DOC21/78096

Senders ref: SSD 10457 (Blacktown)

Subject: Notice of Exhibition – Eastern Creek Retail Outlet Centre, Rooty Hill Road South, Eastern Creek (SSD 10457)

Figure 8: Proposed Offset Areas (Ecological Australia)

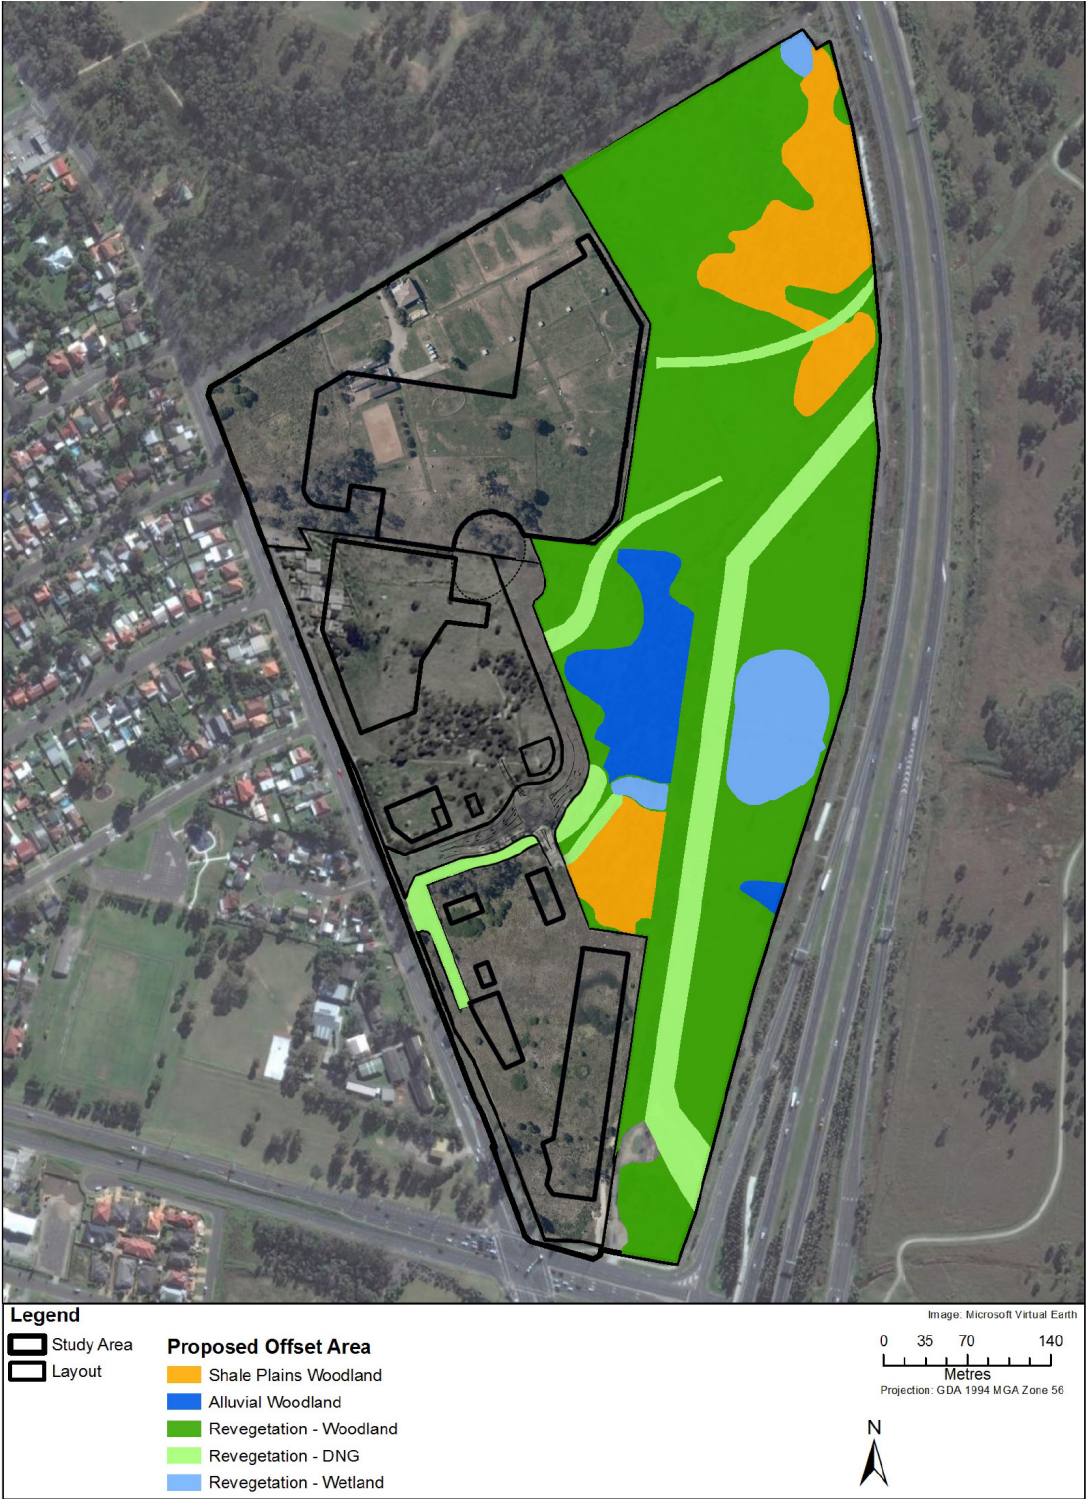
EES notes that in 2014, approval was granted for the Eastern Creek Business Hub (SSD 5175). The Ecological Assessment for this SSD argued that while 1.93 hectares of the critically endangered ecological community, Cumberland Plain Woodland (CPW), was to be lost, these losses would be offset via a Biodiversity Offset Strategy, which included the retirement of 46.3 ecosystem credits and retention of native vegetation in a 'Proposed Offset Area'. The patch of CPW which is proposed to be cleared in the current SSD 10457, was identified as one of the Proposed Offset Areas in SSD 5175 (see Figure 20).

#### OPTION 3 (CURRENT)

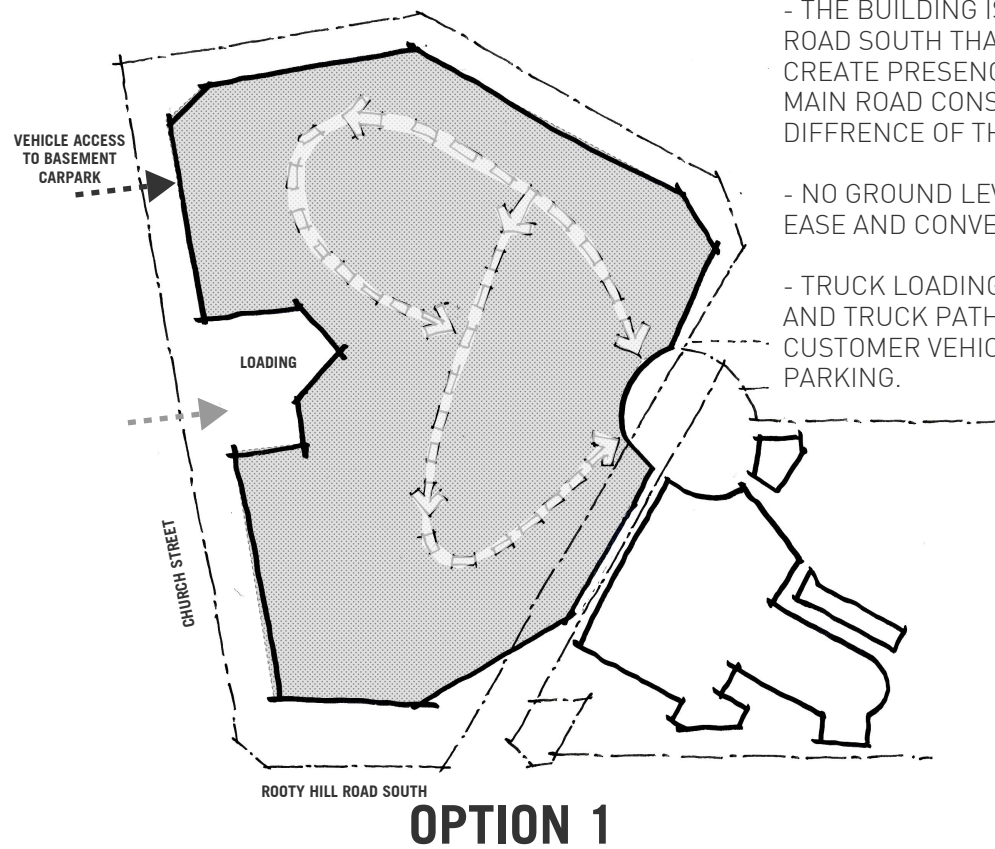
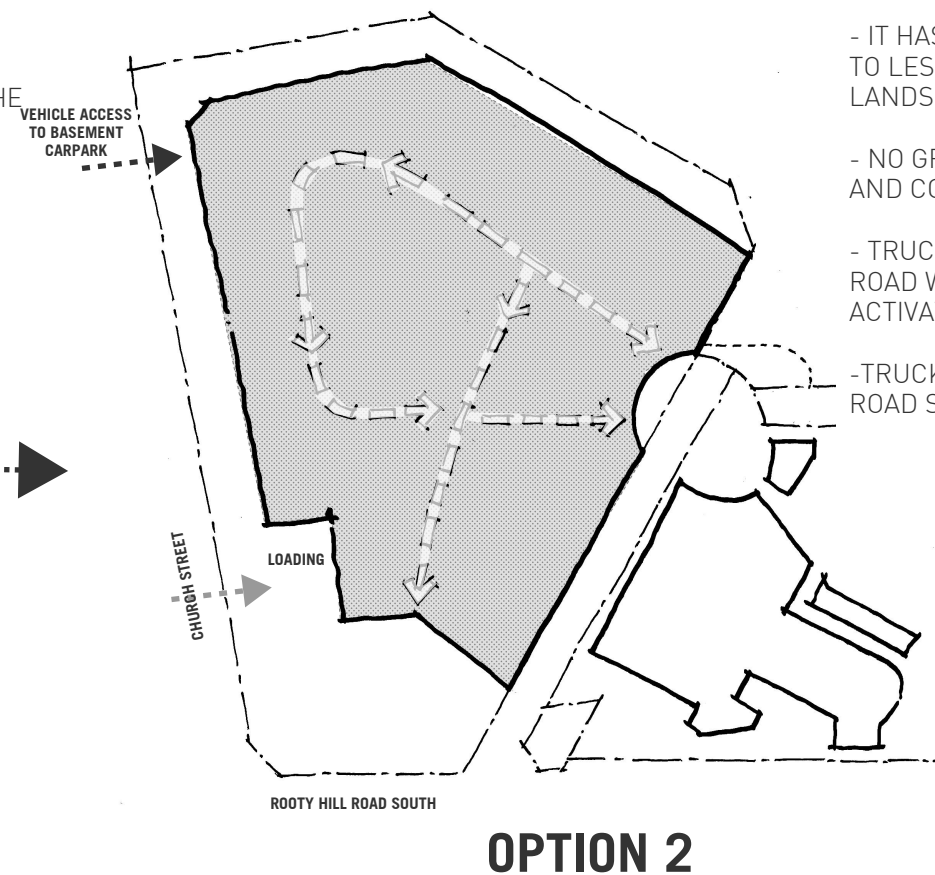
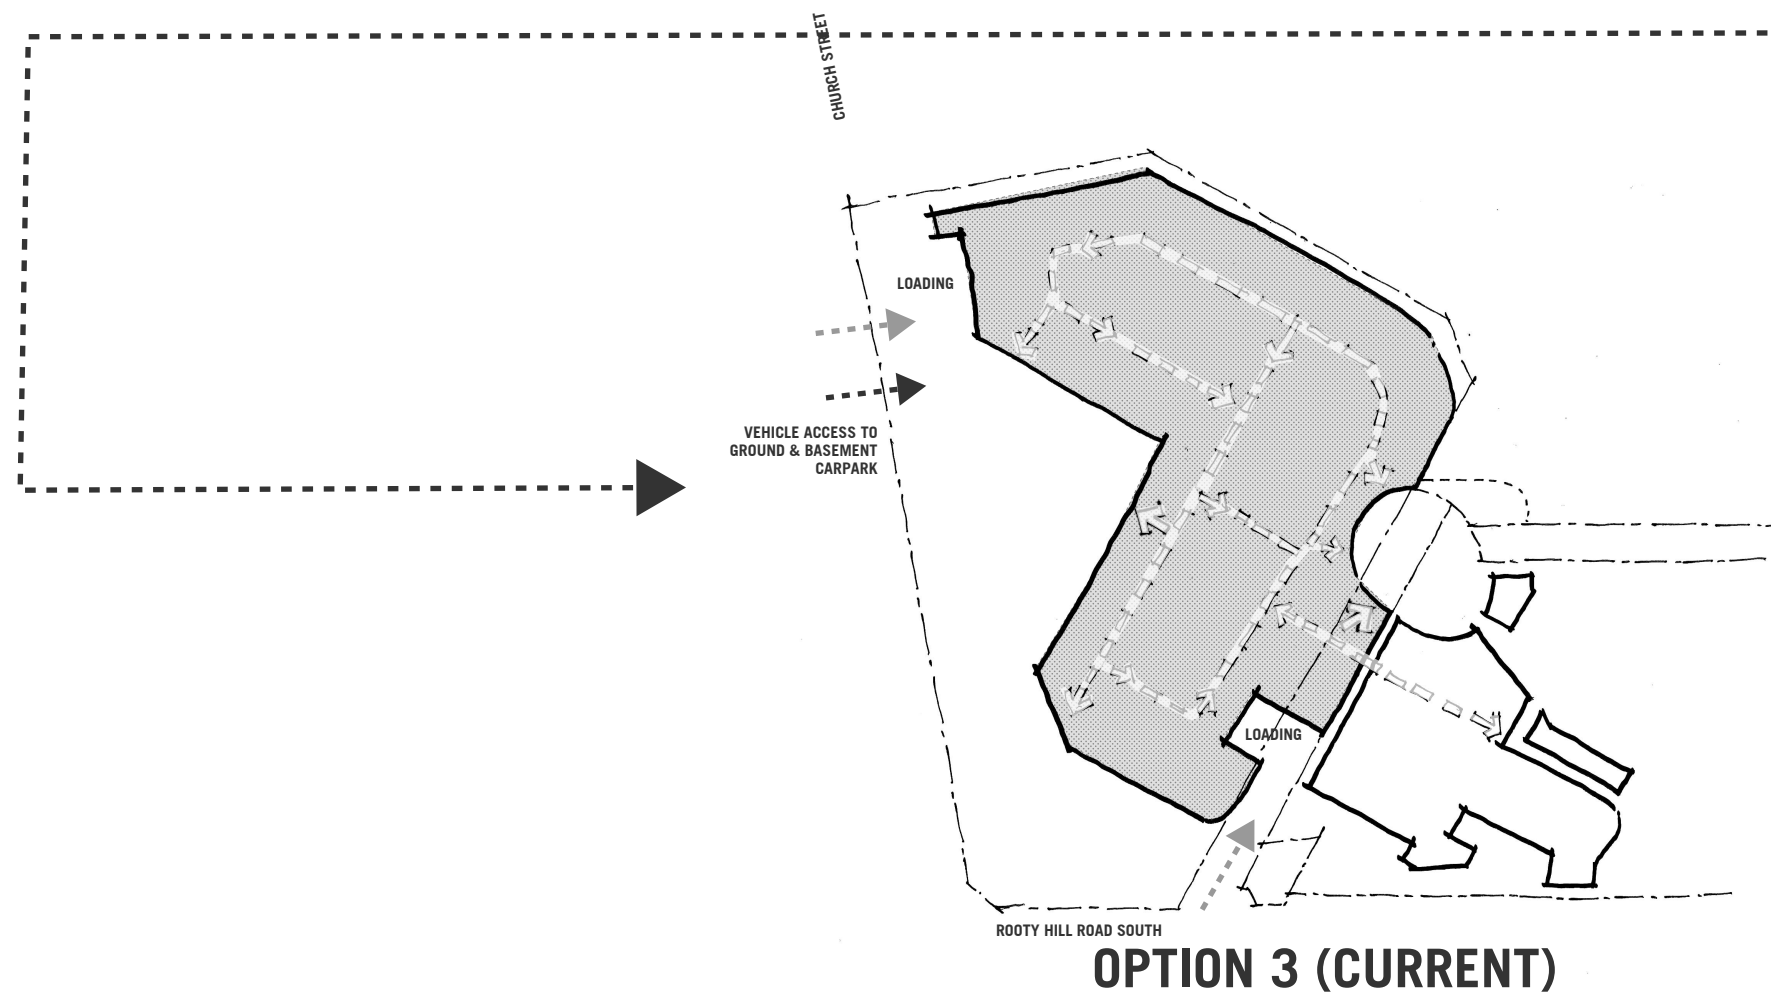
The BDAR states there have been 23 iterations of the development footprint that have considered all constraints relevant to the proposal, which is a large number. EES requests confirmation that there have been 23 iterations of the development footprint of the subject site for this SSD. Some examples of these iterations would also be useful.

It is noted that Appendix B of the EIS includes some design options that were considered; however information should be included in the BDAR that details the design options considered to avoid biodiversity impacts.
